Subject: RE: Nyton House care home dementia ward AL/42/19/PL

We would welcome the hiping of the western roof gables. This would also reduce the impact on the occupiers of Knighton Grange (they have partly objected to the impact on their view).

1. View from Knighton Grange (At 1.8m Height)

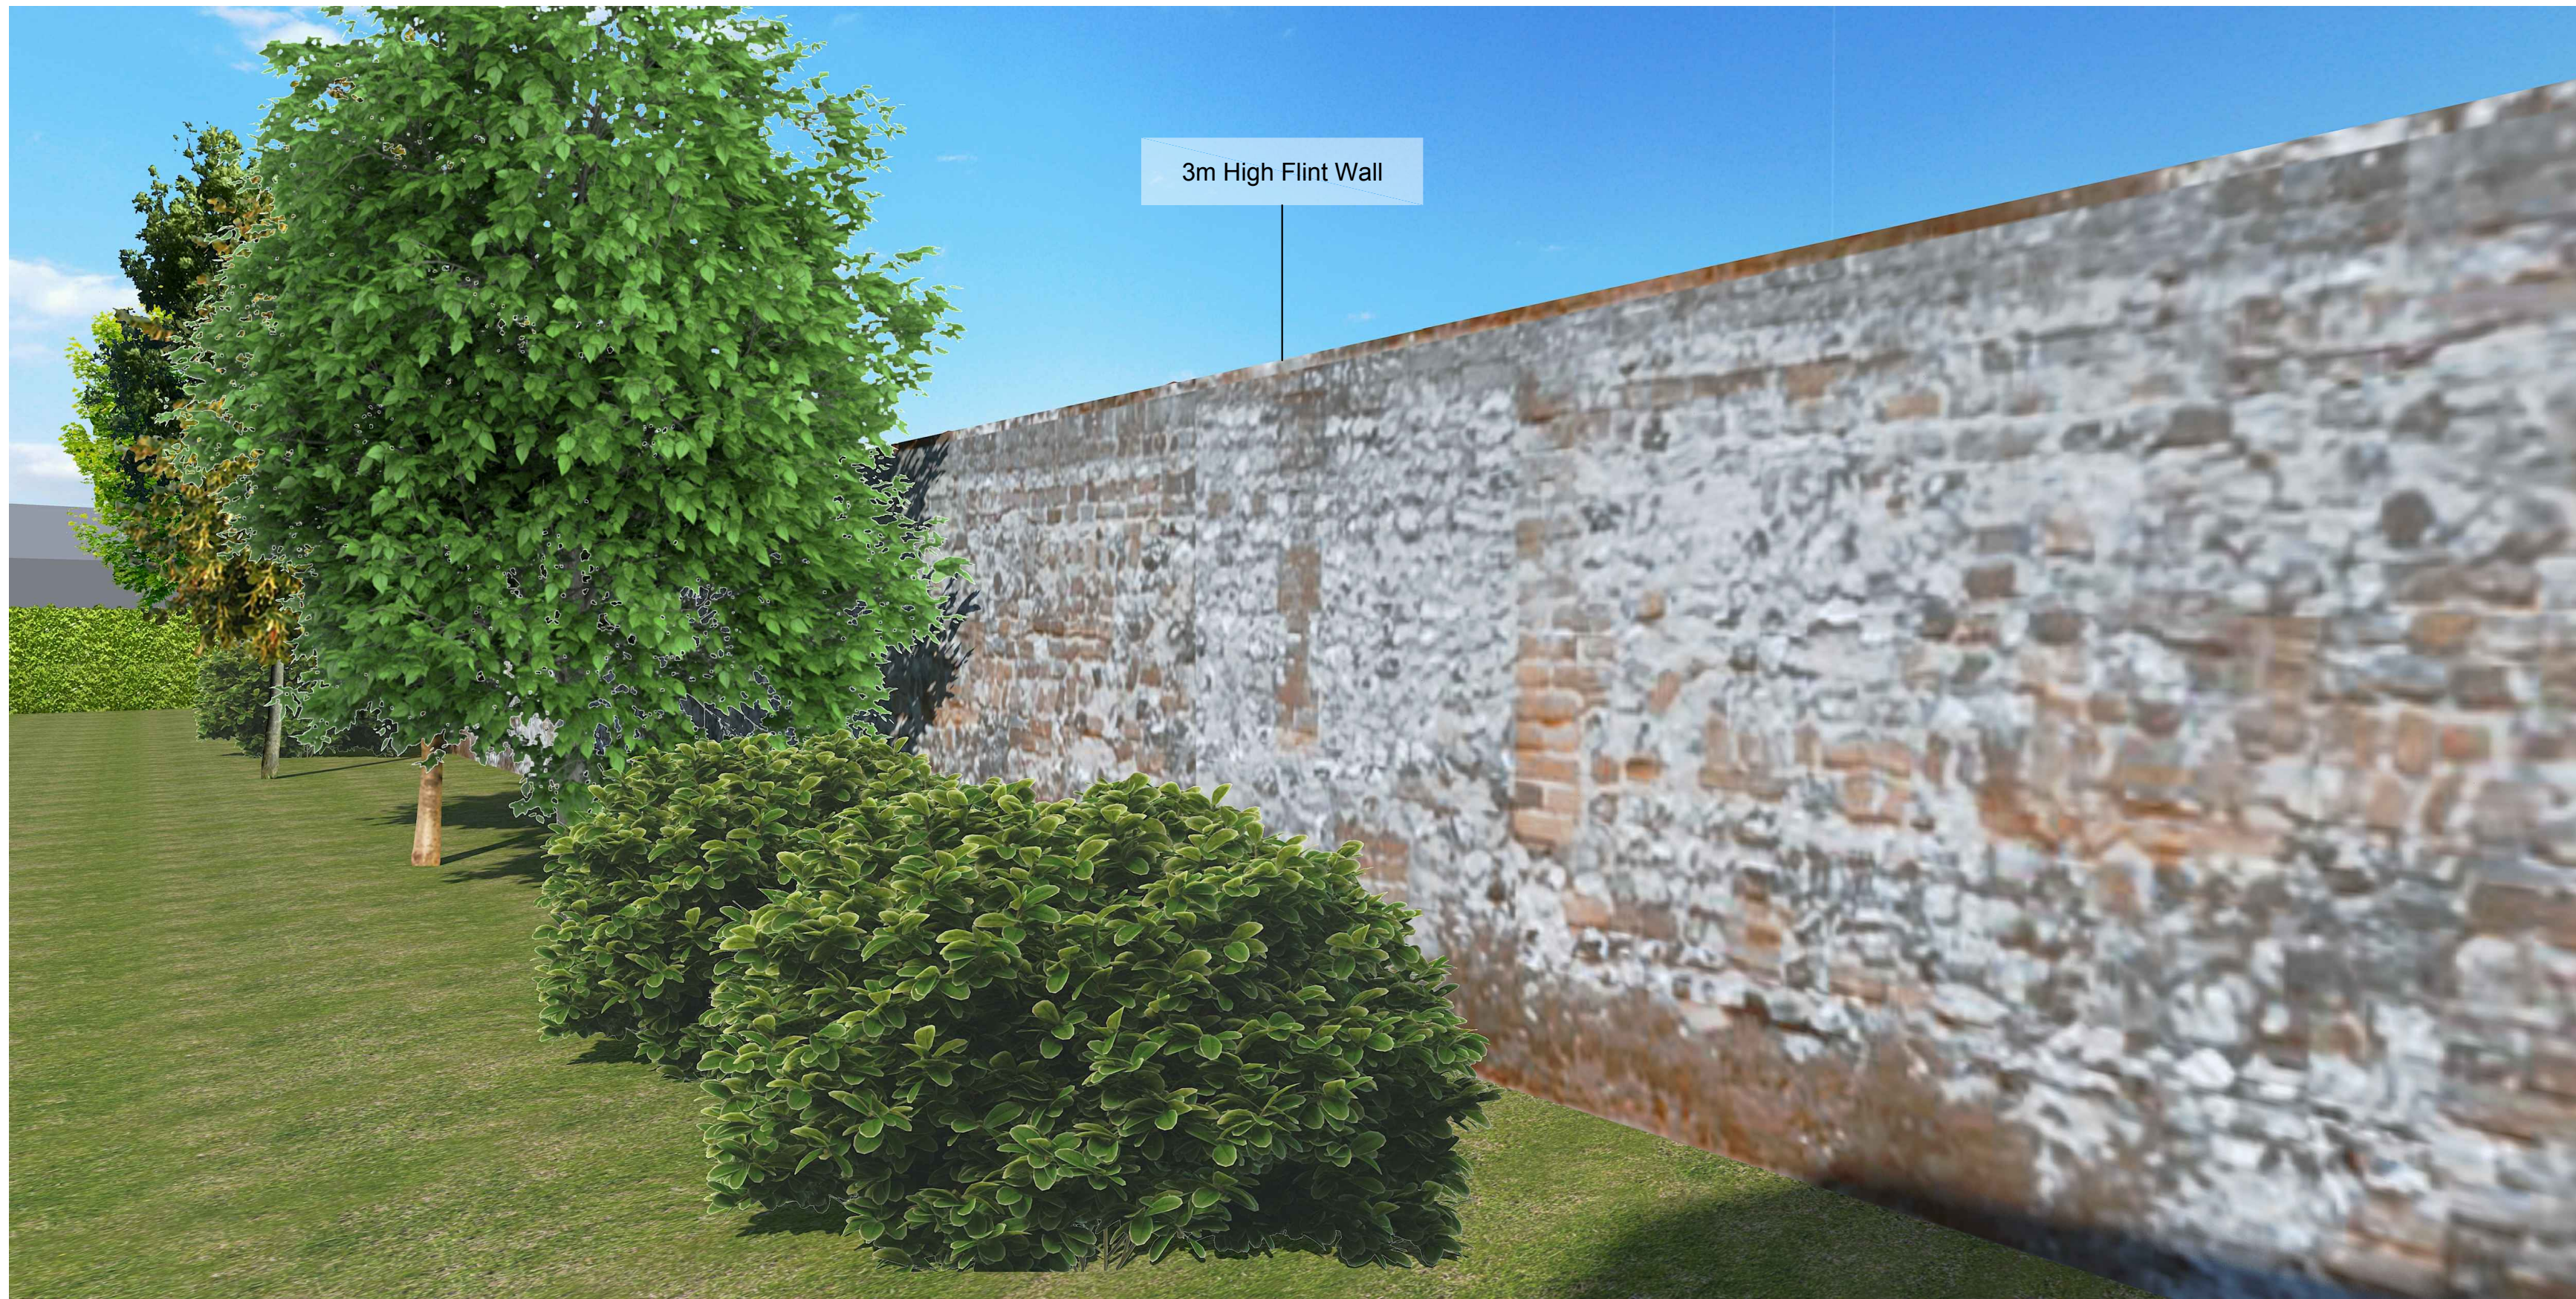
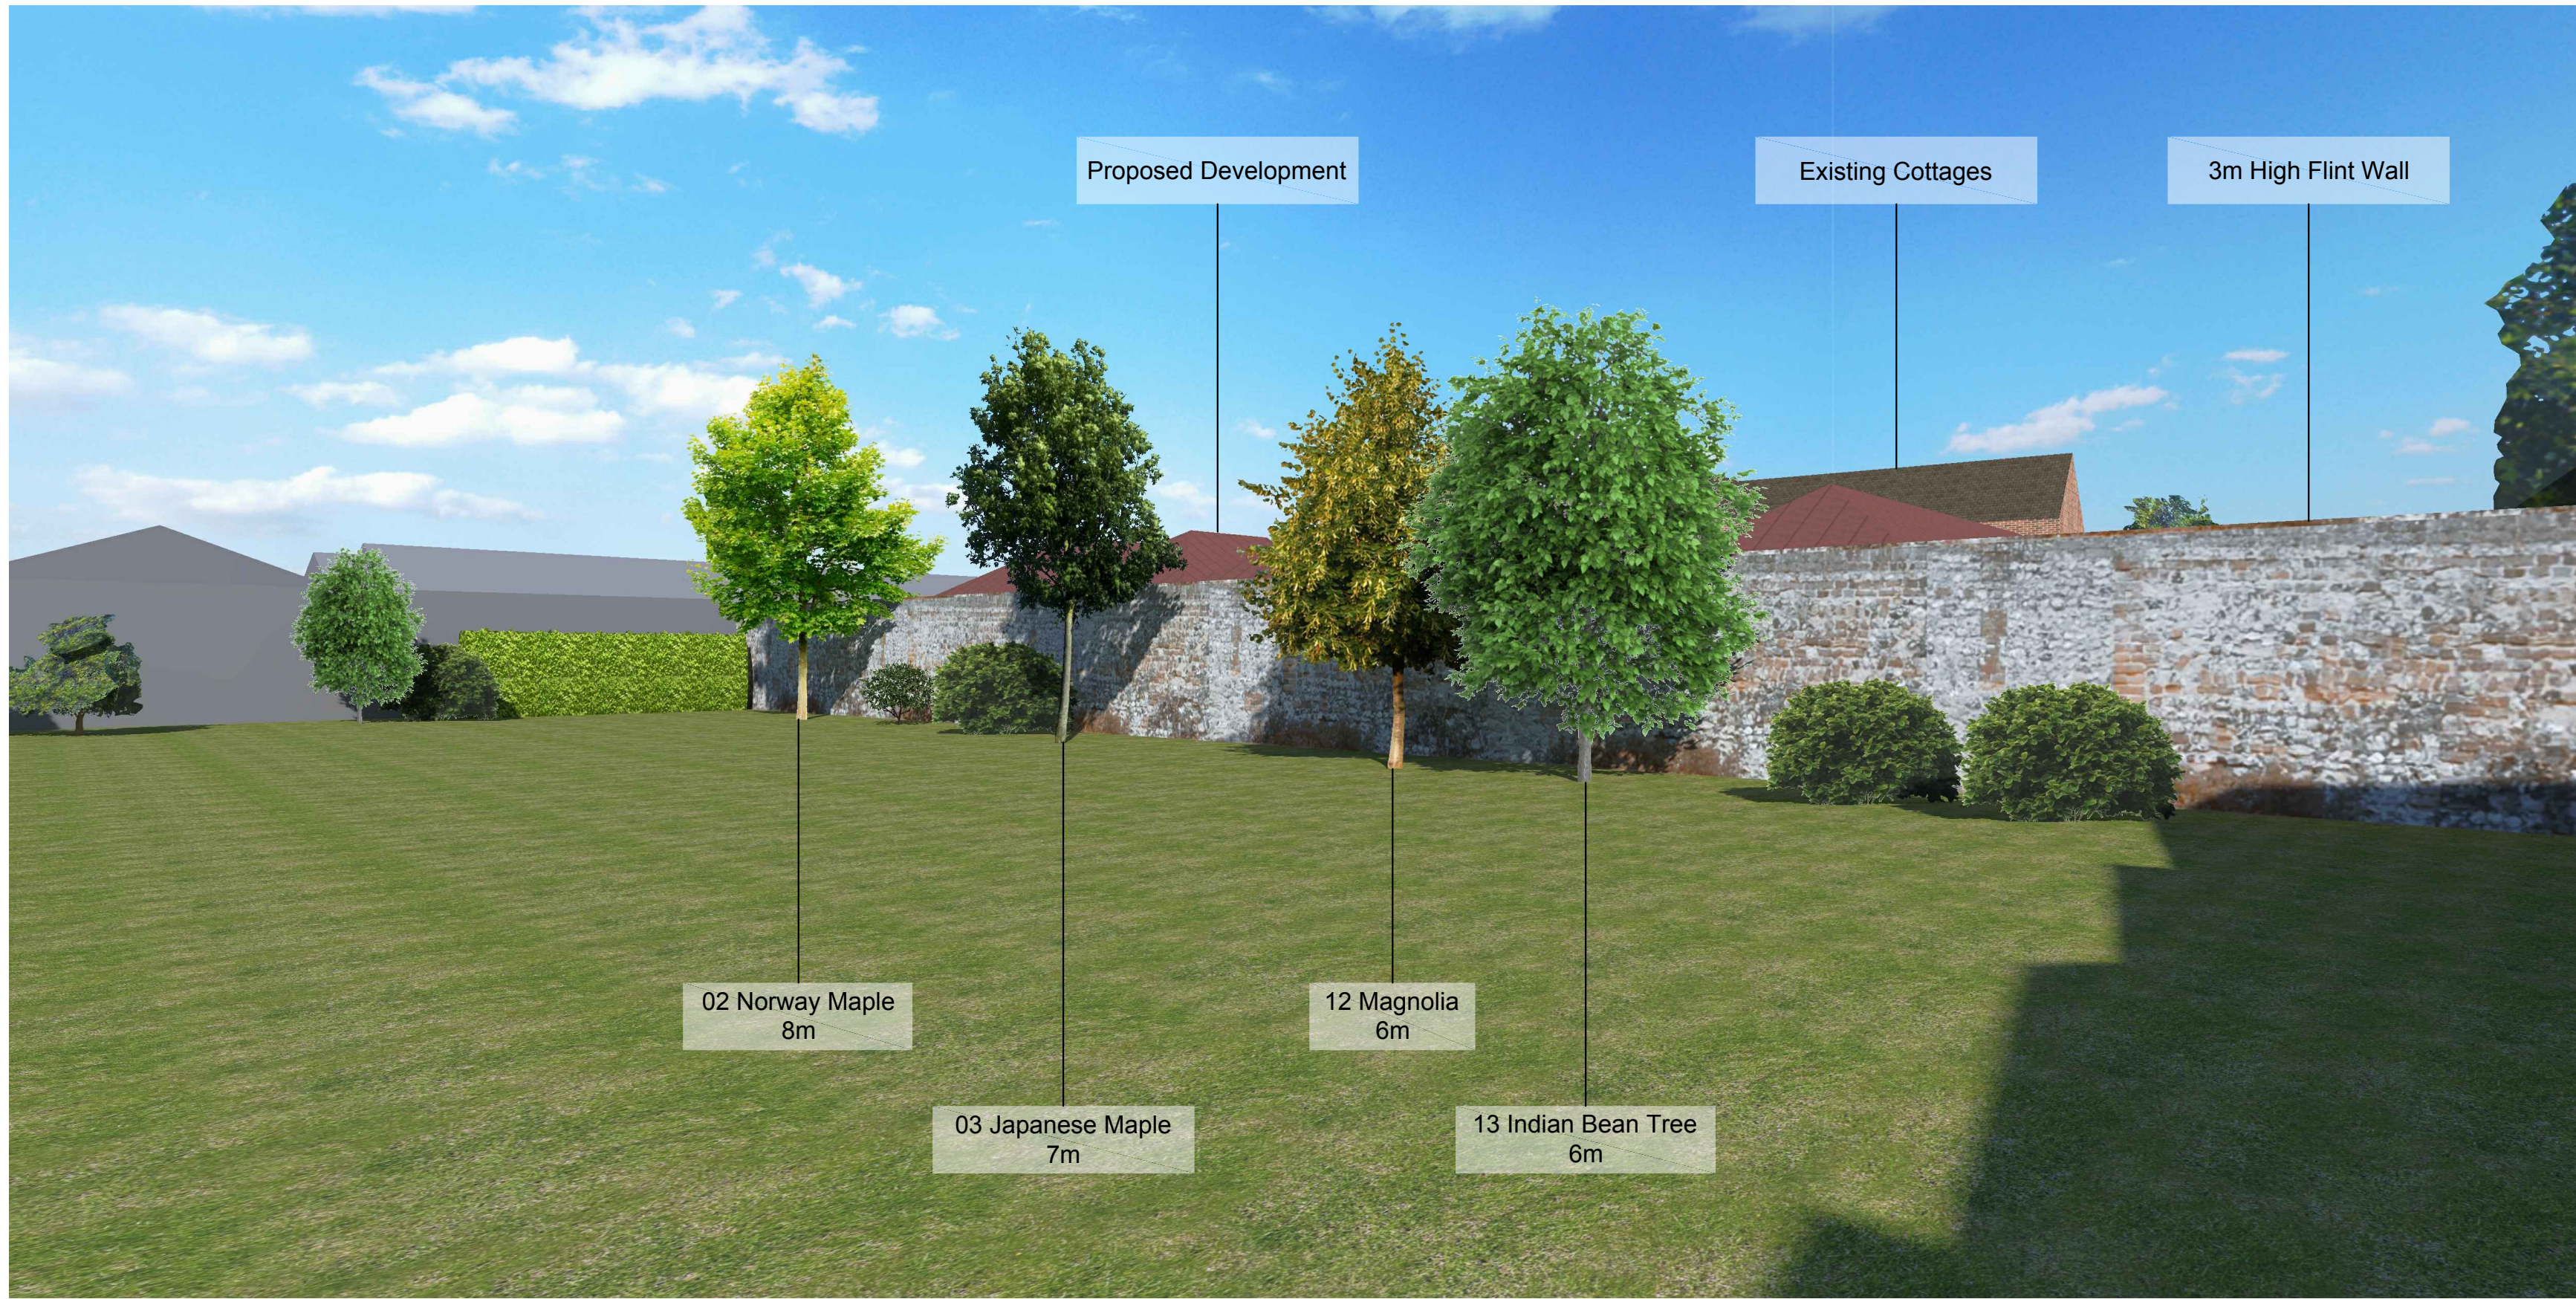
You may also wish to prepare some form of visualisation drawing to demonstrate what the view from Knighton Grange would be? This could help at Committee.

I would like to suggest that, in order to reduce this impact further [we have obviously reduced this enormously already from the initial scheme], we introduce hips to the gabled elements of roof. This will slope the roof of the building away from the boundary and reduce the massing of the apex of wall to a sloping roof face diminishing as it moves away from the neighbouring property.
